Recommendation Report for Planning Permission

REF NO: BR/229/17/PL

LOCATION: Land to rear of 41 - 47
Pevensey Road
Bognor Regis
PO21 5NY

PROPOSAL: Erection of 3 No. dwellings, 1 No. detached garage, parking & alterations to existing access & driveway (resubmission following BR/200/16/PL).

Tree Constraints Plan and Tree Retention Plan

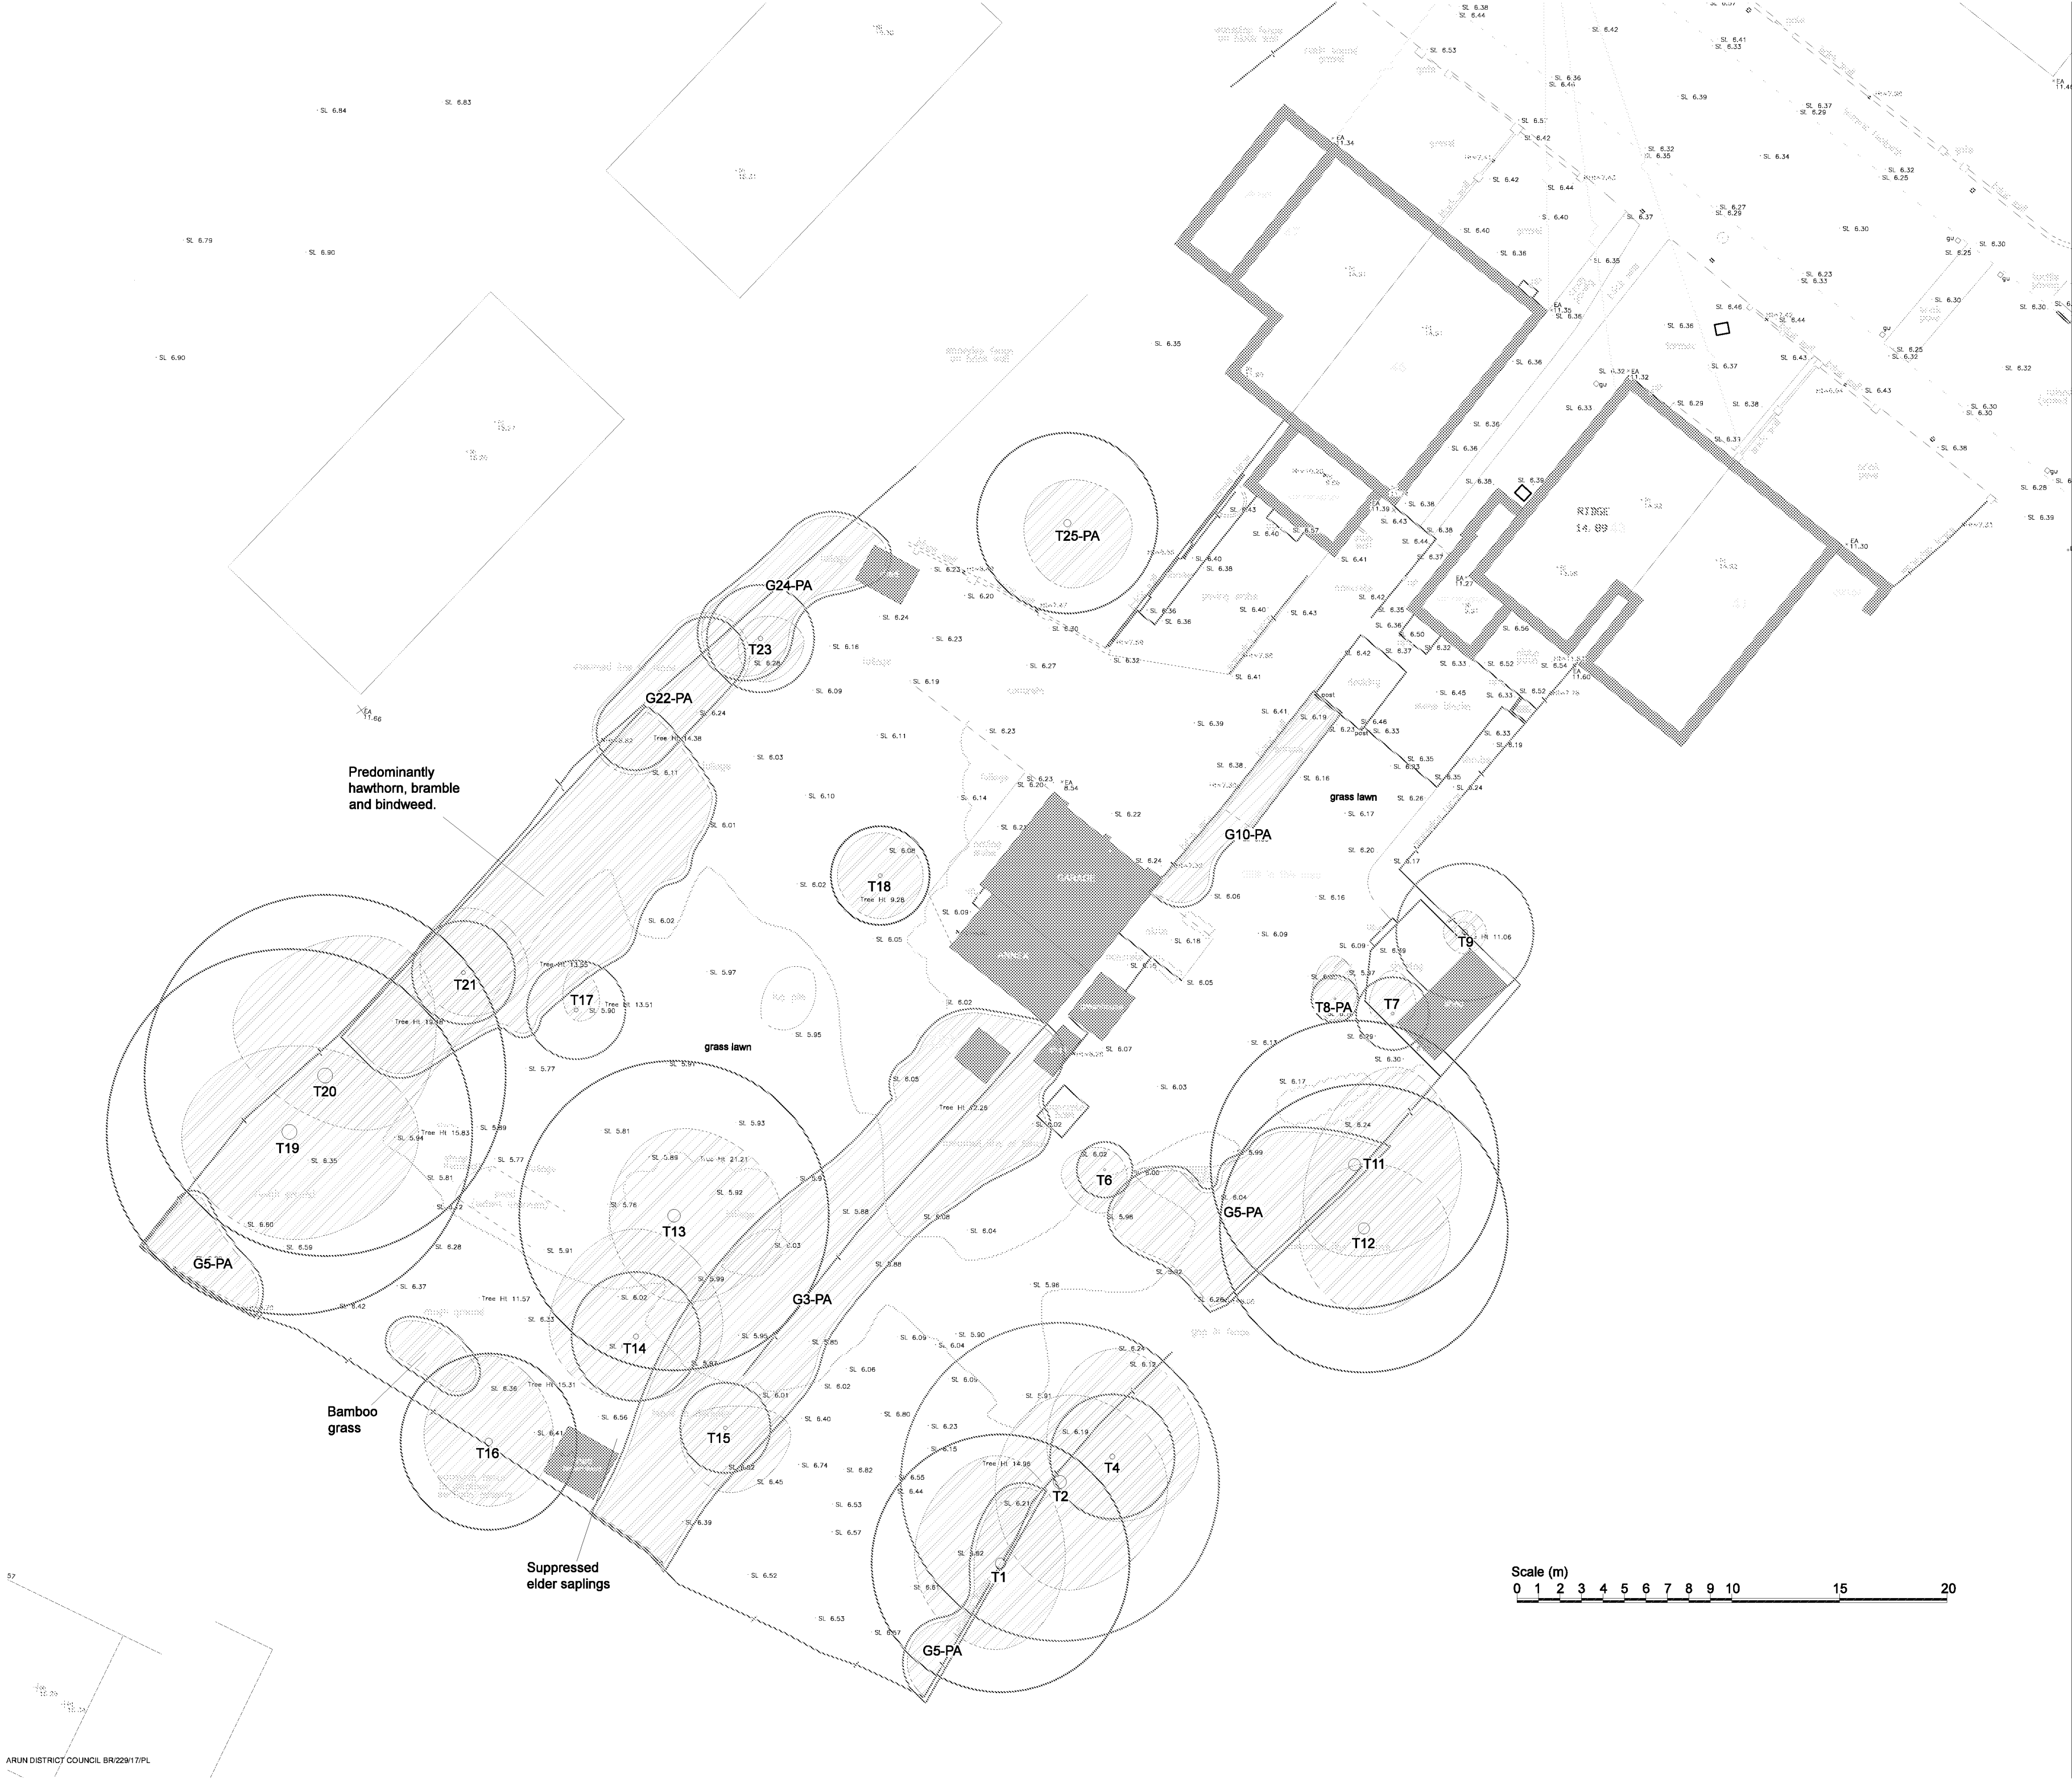
- (1) There are trees both on and off this site of value which has been recognised by ADC in the making of a TPO to cover T2; T12; T13 and T20 (numbering taken from the PJC tree survey).

- (5) The building on plot 3 will be shaded by off-site trees in the garden of No 39 (primarily TPO trees T11/12 & T2) so there will still be pressure to prune or fell that would be difficult to resist on application.

- (6) Although plot 1 now has a larger garden but there will still be shading from trees T19 & T20 (T20 being a TPO) and thus pressure to prune or fell in the future.

Tree Protection Plan

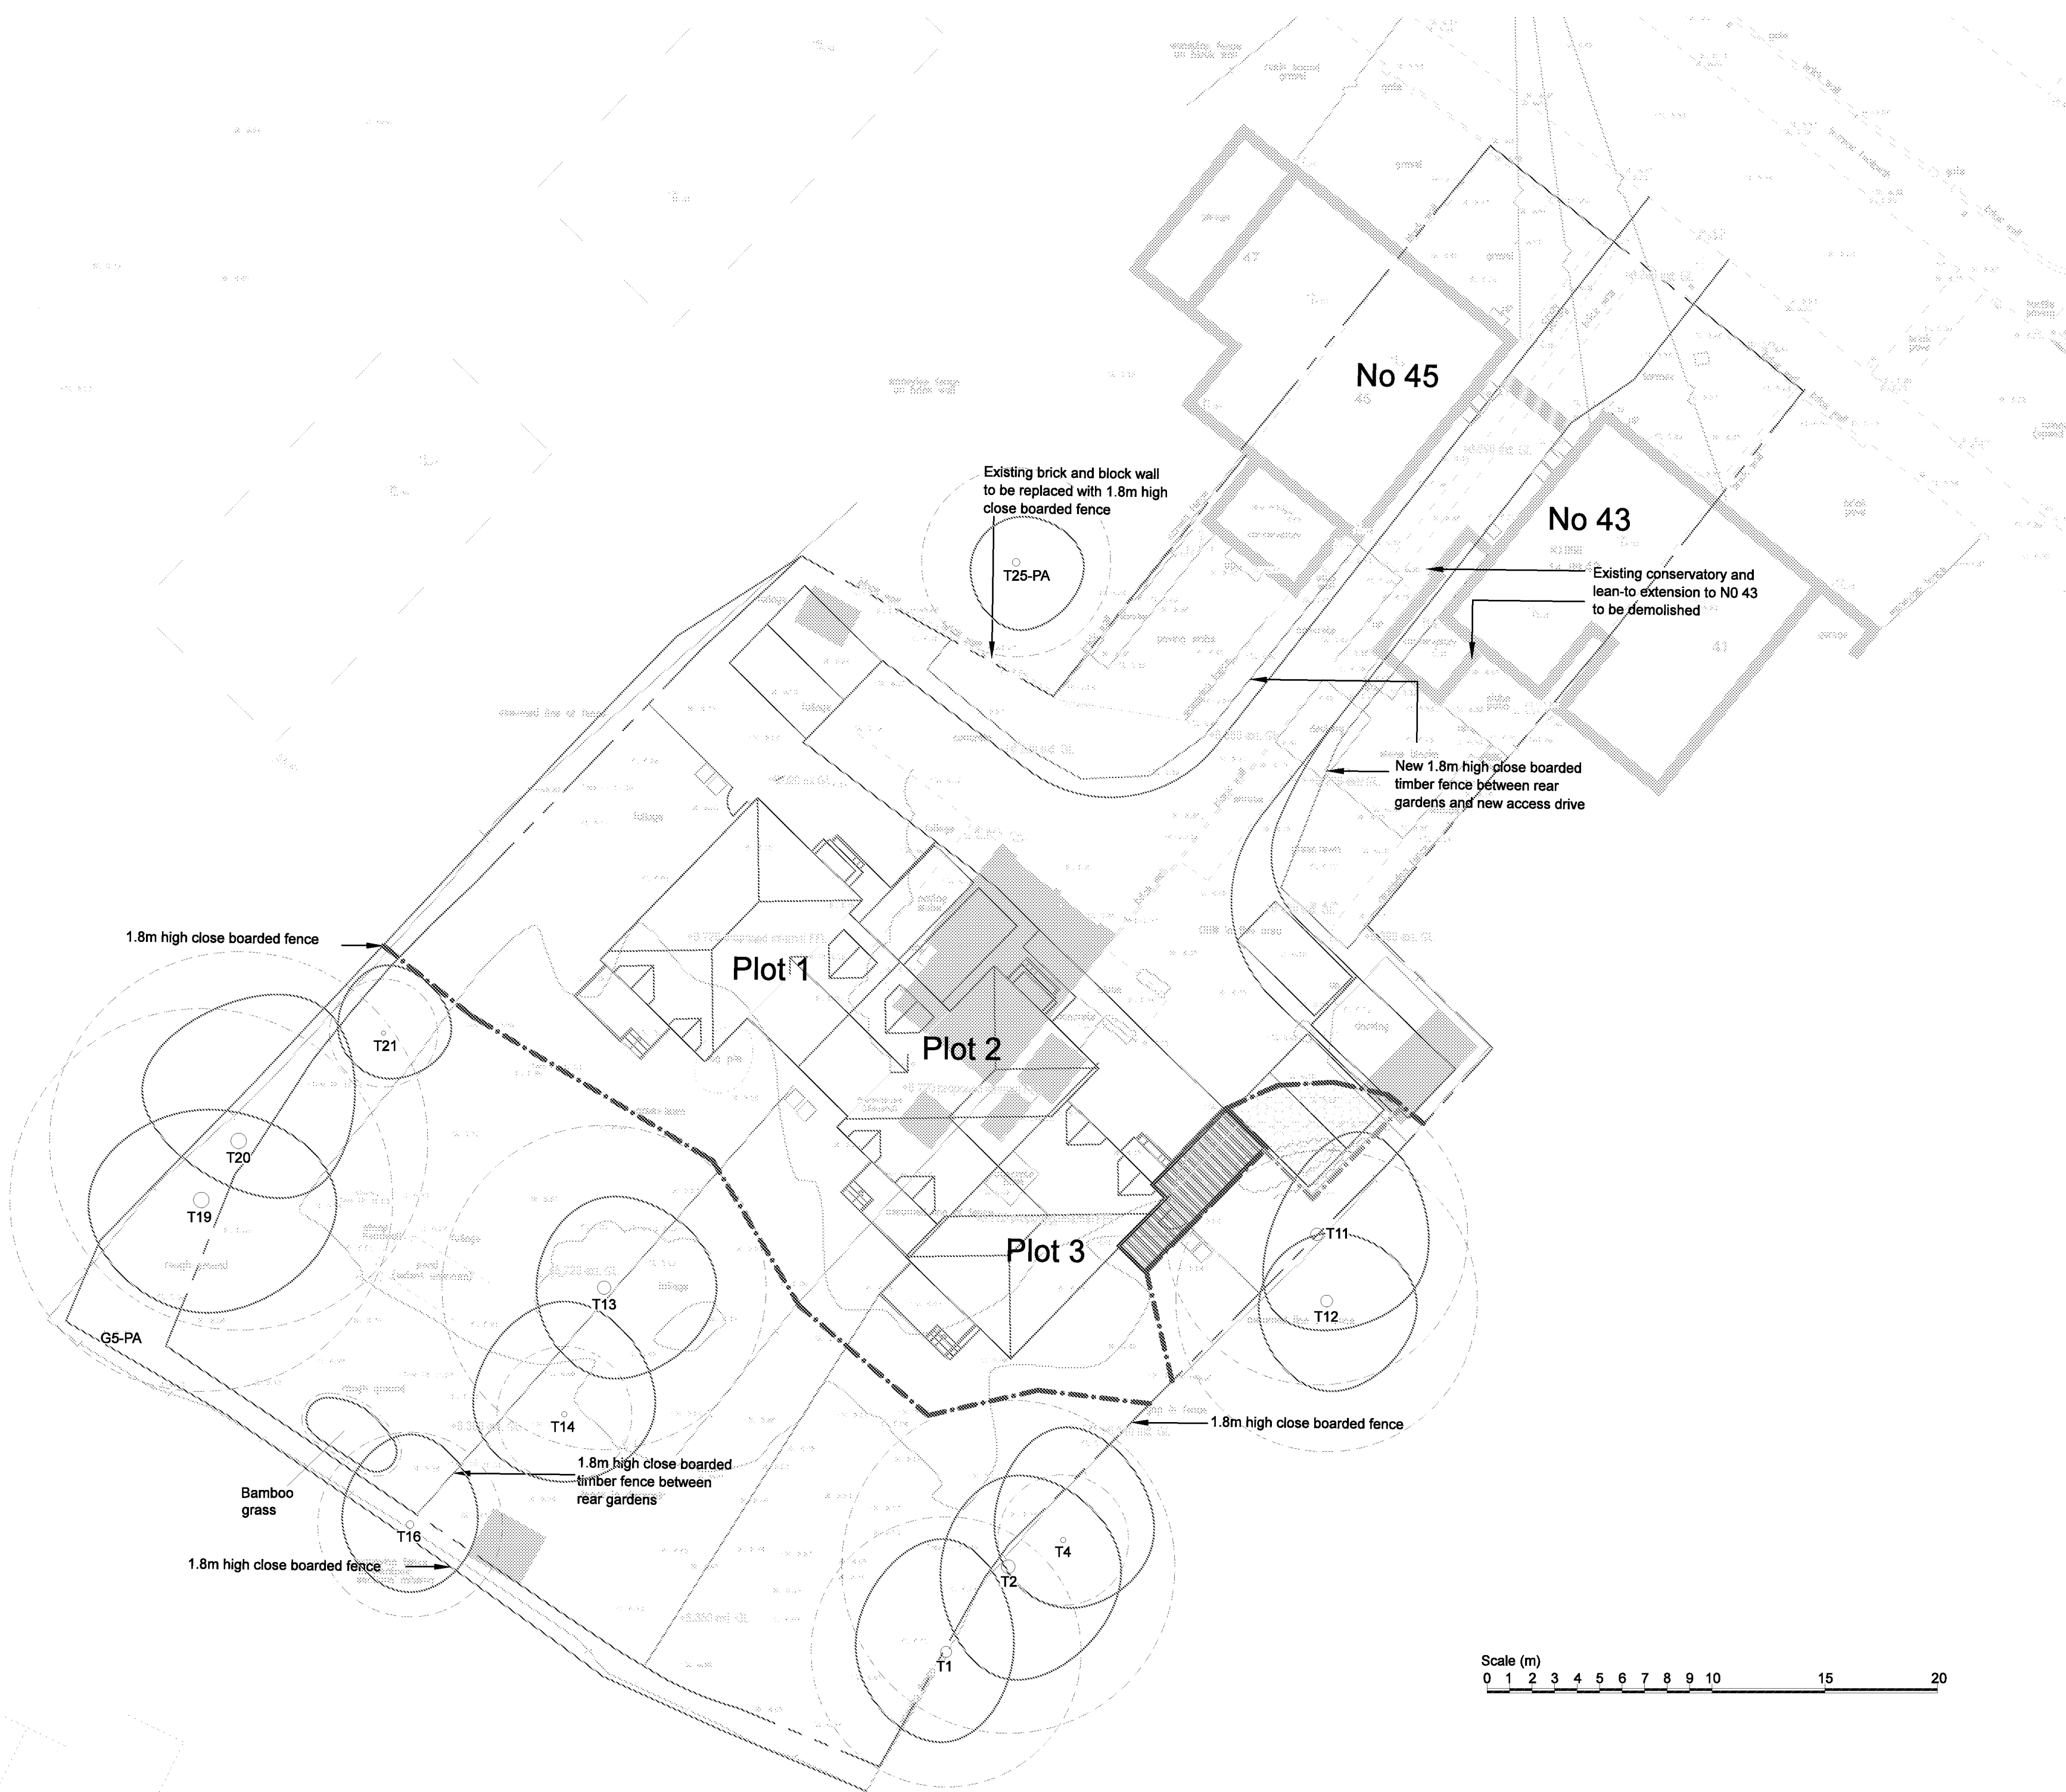
ADC TREE OFFICER - Raise objection on the grounds of intense shading of proposed gardens from existing retained trees resulting in pressure from future residents to prune or fell these trees. Also question the viability of applying a 'No Dig' situation adjacent to trees T11 & T12 for the parking bays. Detailed comments summarised as follows:

- (7) Whilst there is provision within BS5837 to mitigate the effects of the car parking within the RPA's of T11 & T12, it would be better if this was designed out rather than use a 'make it fit' approach.

- (8) Also concerned as to whether the new levels would allow the proposed 'No Dig' situation to be applied.
